Application no: H16/0797/00

Applicant: Cley Developments Ltd.
Willow Lodge
Horseshoe Road
Spalding
Lincs. PE11 3JA
Description: Proposed dwelling and garage

Location: Plot 1, Westbourne Gardens
Spalding

Amendment: Dwelling repositioned - brought forward on plot, garage
reduced in length, en-suite rooflight sited on n. elevation

Drawing Title
Elevations

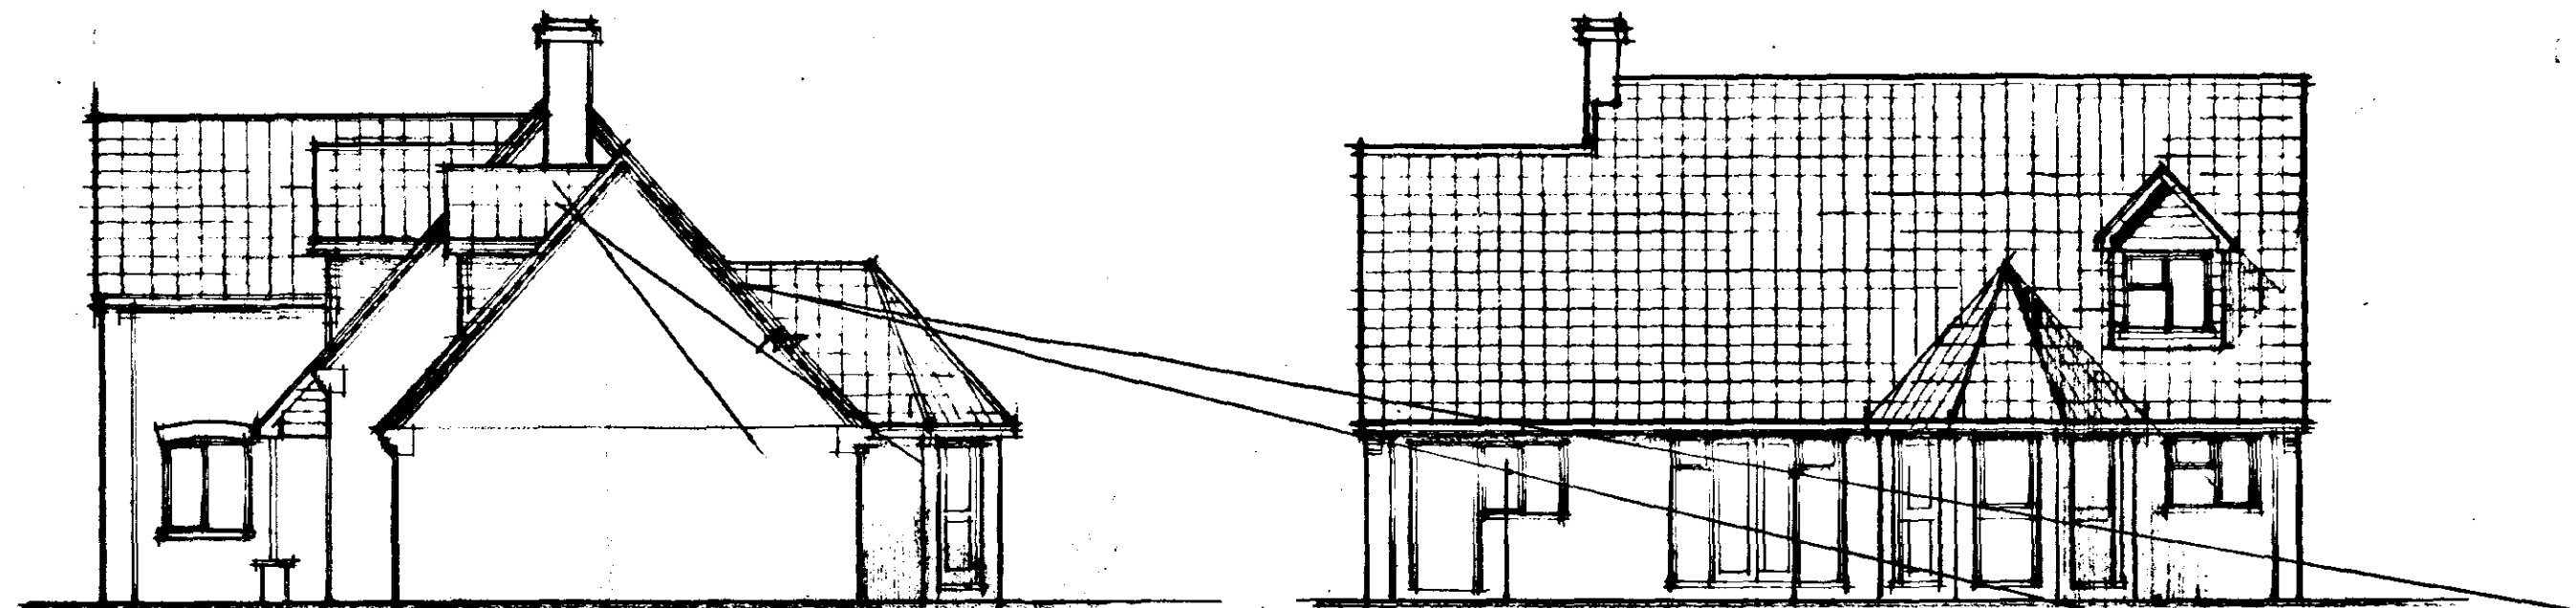
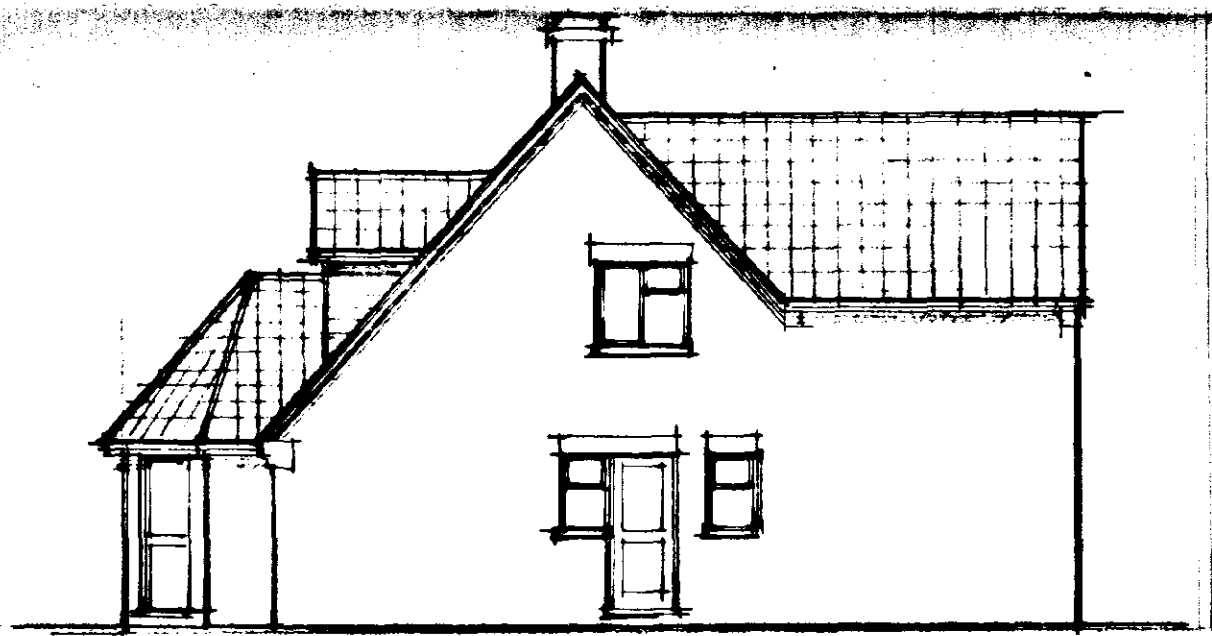
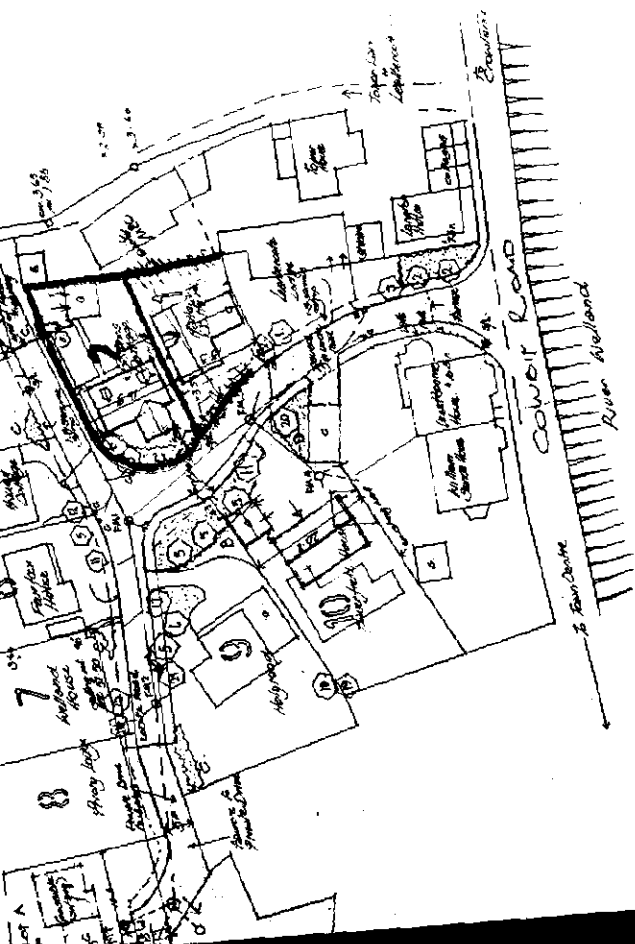
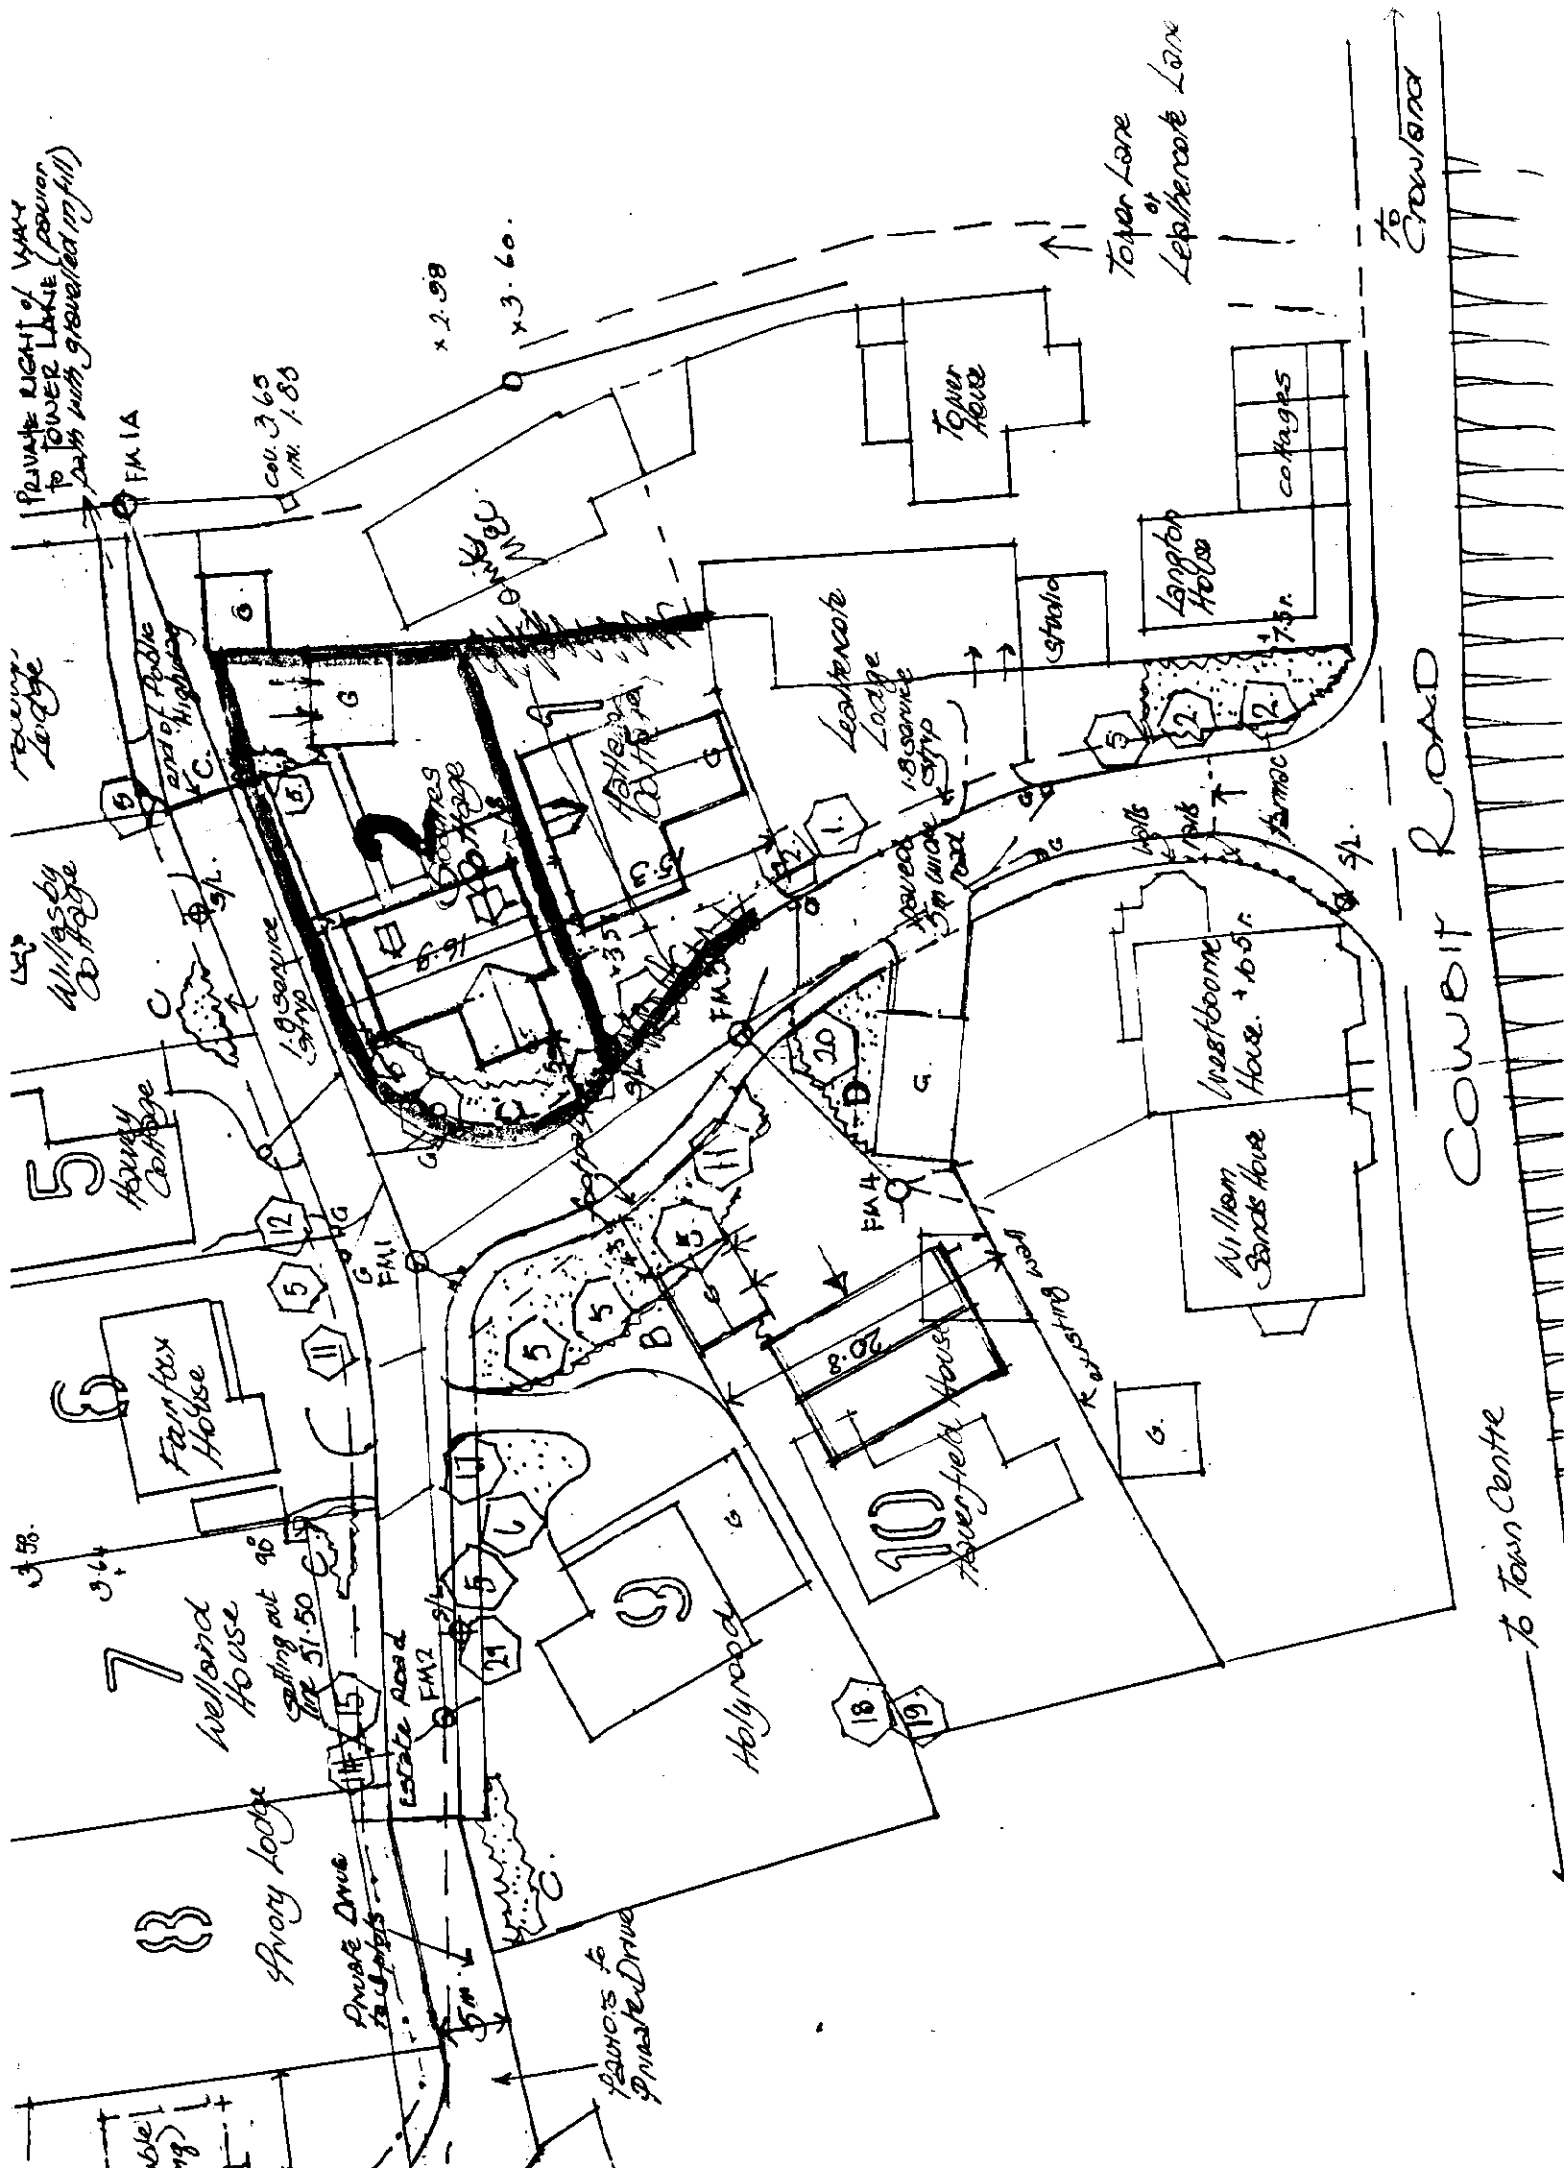
SKEDLINE REPOSITIONED - BROUGHT FORWARD ON PLOT.
GARAGE REDUCED IN LENGTH ON SUITE ROOFLIGHT SITED ON NORTH ELEVATION.
